ATP Locomotive Workshop (Bays 5 - 15) (SSD-8449-Mod-4)
Request for Additional Information

I refer to the modification application for alterations to the internal design and layout of Bays 5 – 15 of the Locomotive Workshop (SSD-8449-Mod-4).

Schedule 1 – Additional information

4 INTERTENANCY WALL SECTION
1:25

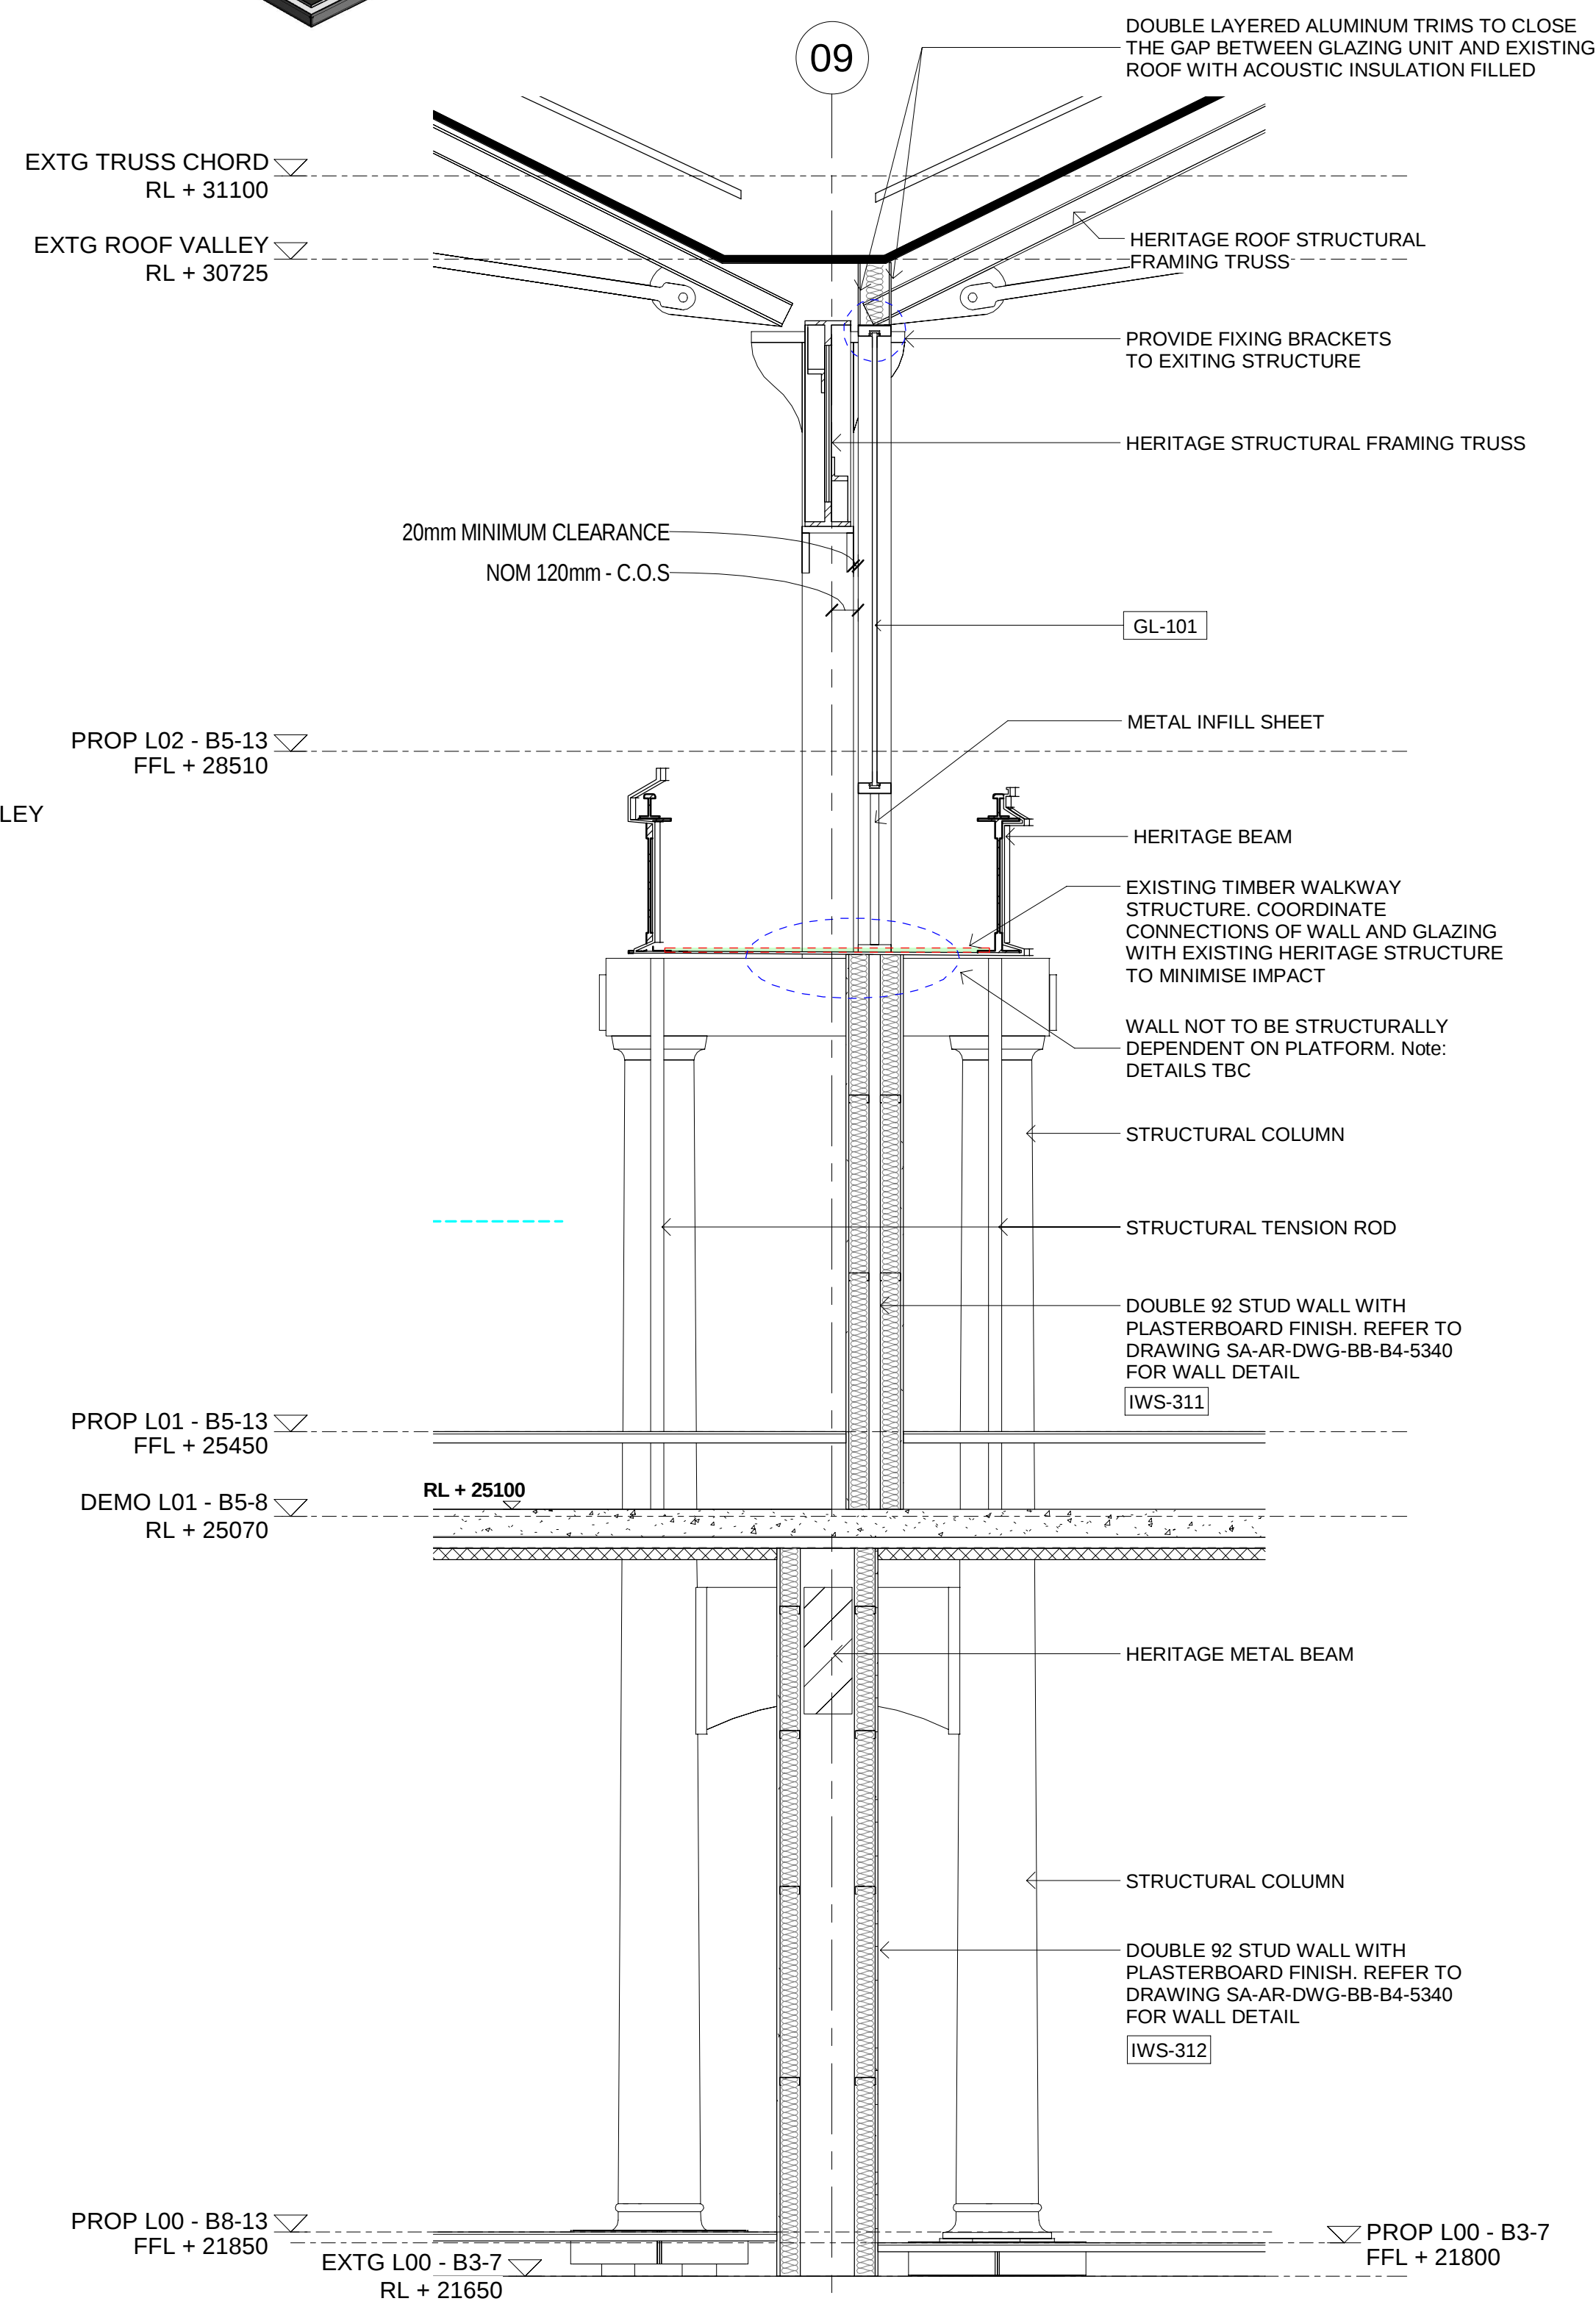
- Identify the material proposed for the intertenancy wall that is proposed to be moved from gridline 9 to 10 (item 14).
- Confirm the GFA calculation changes from approved plan, SA-AR-DWG-BB-B4-0250 Rev T, to the submitted plan, SA-AR-DWG-BB-B4-0250 Rev U.

Drawing Title
PROPOSED PLAN - GROUND FLOOR

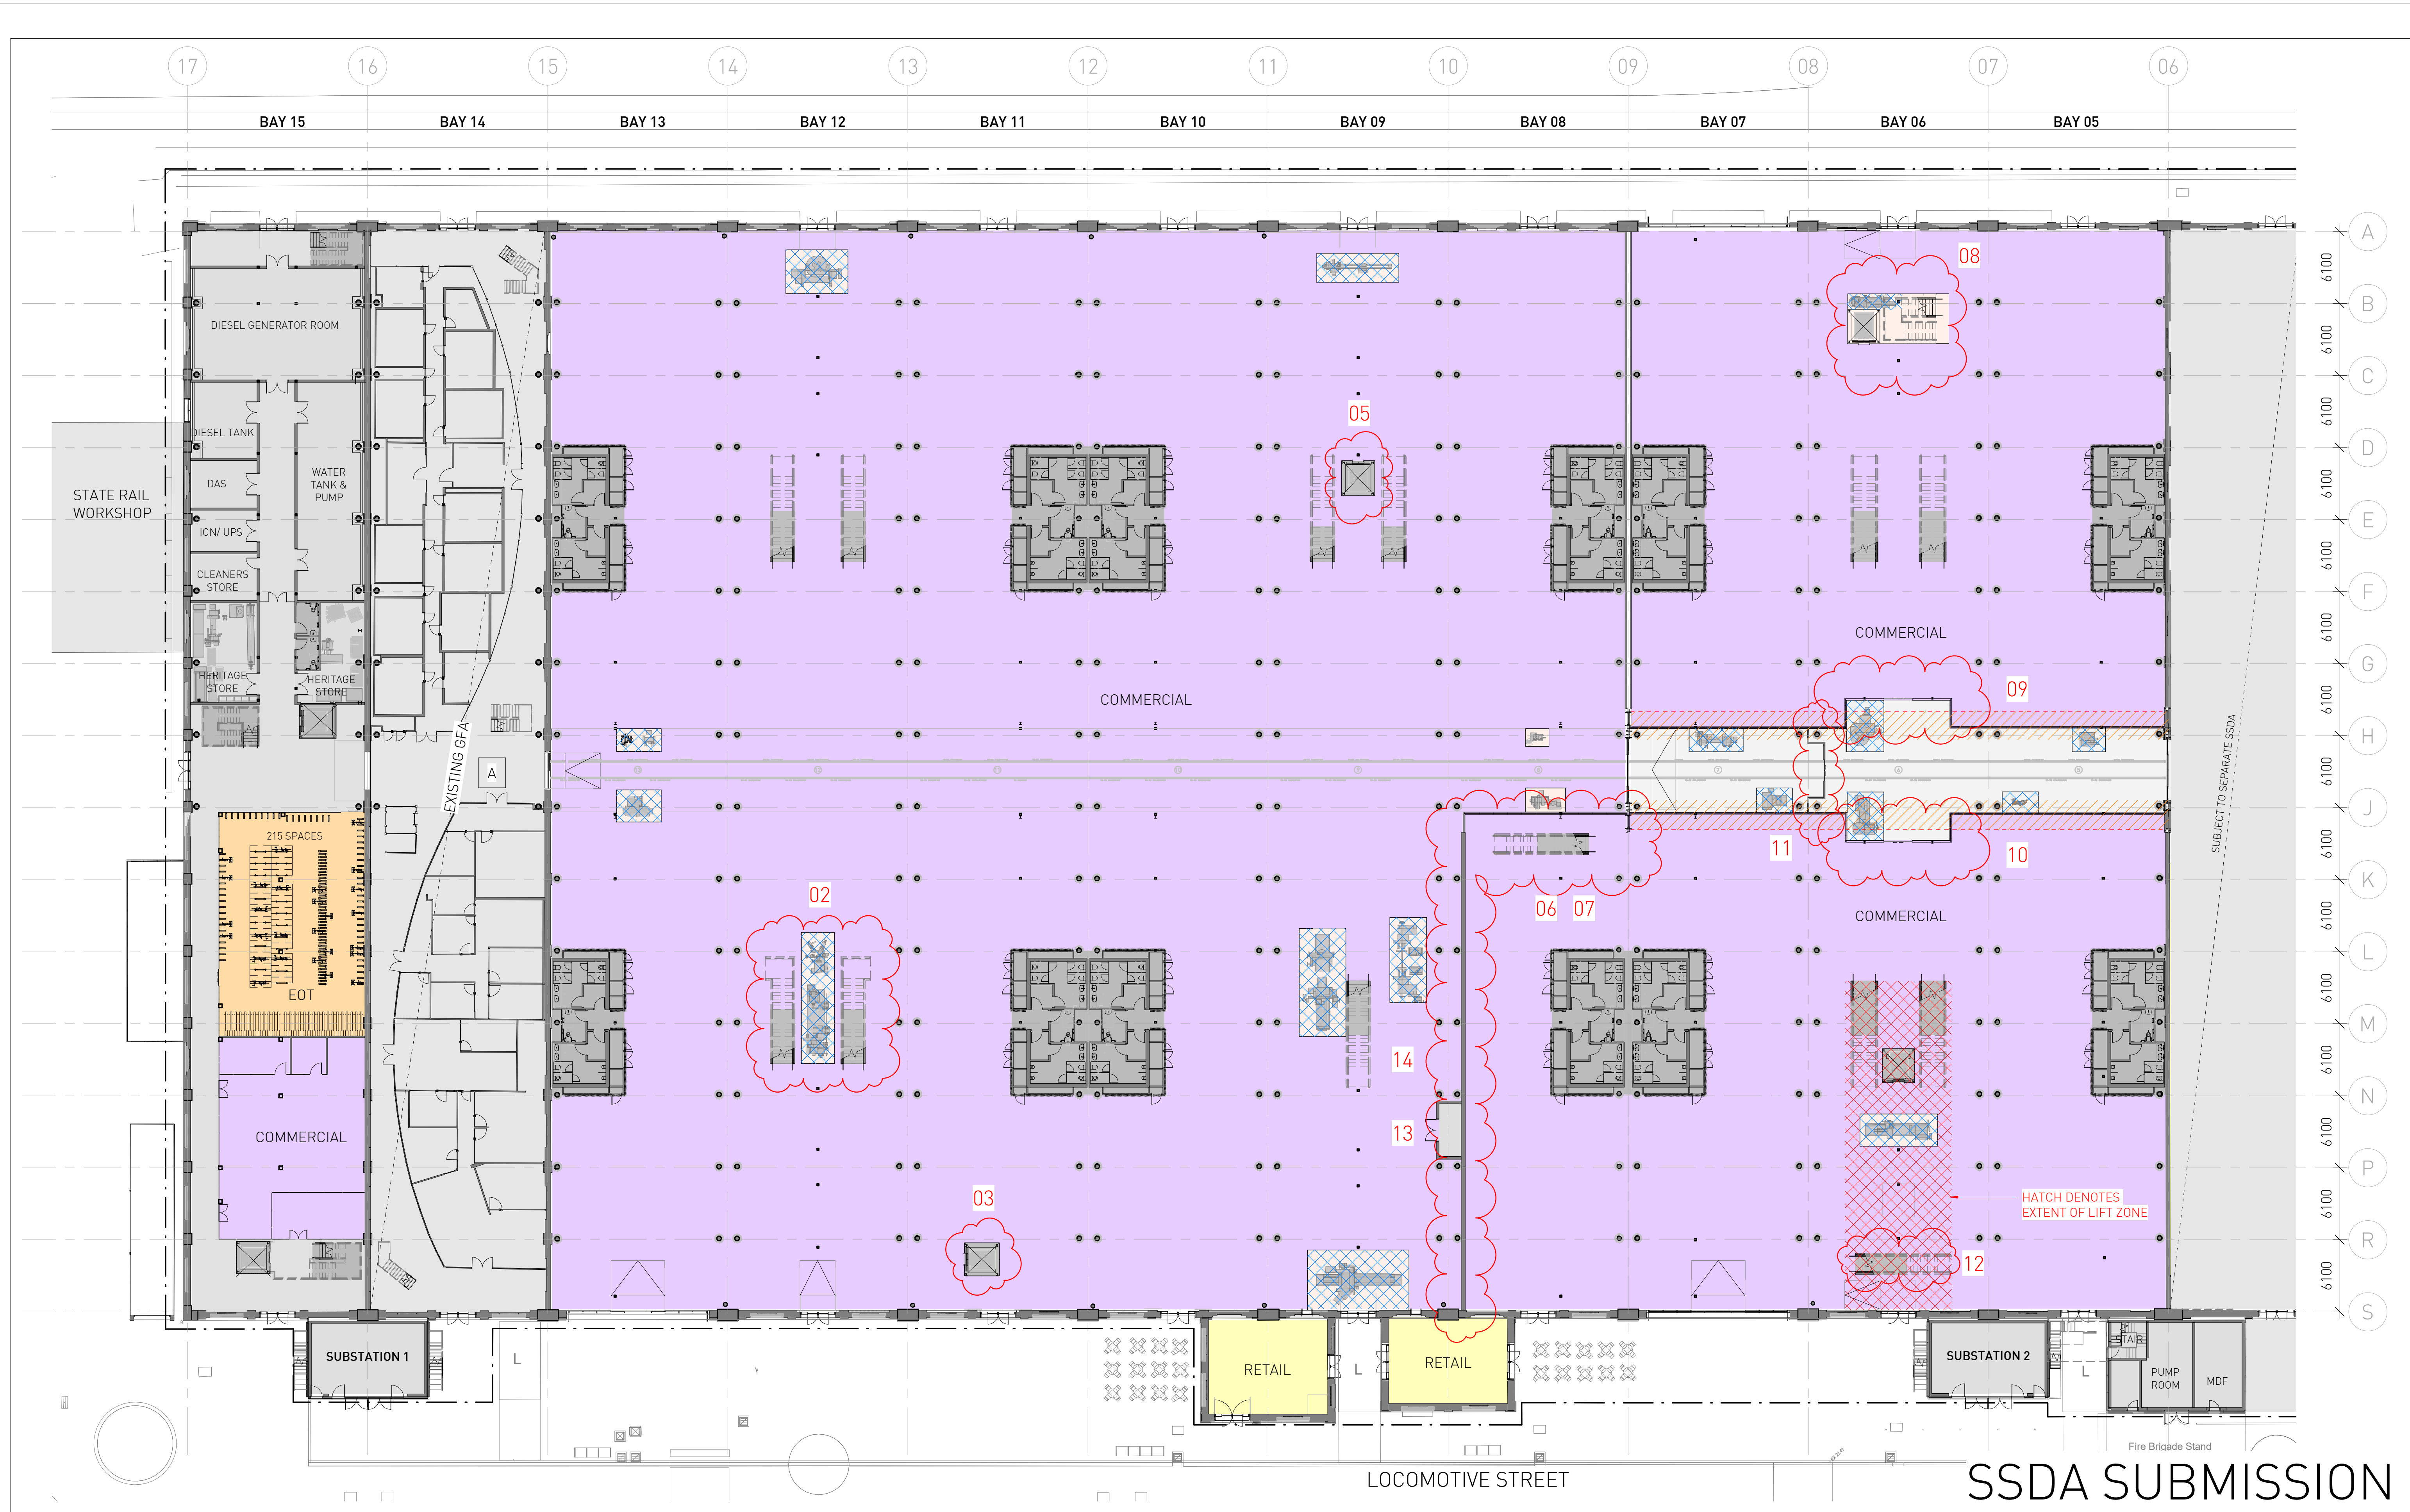
- Clarify why two additional stairs (items 6 and 12) are required for the southern tenancy located over Bays 5 to 8. It is unclear, as the Modification Report states they are for additional egress in the event of an emergency, while the Heritage Impact Statement (HIS) says they are due to spatial restrictions in the tenancy.

- For item 11:
 - provide a visual image of the central spine showing the proposed sliding door in Bay 7, in addition to the architectural drawings requested by Council

- Remove the red bubble for item 4 from the ground floor plan, as this relates to the increase in atrium size at level 1.
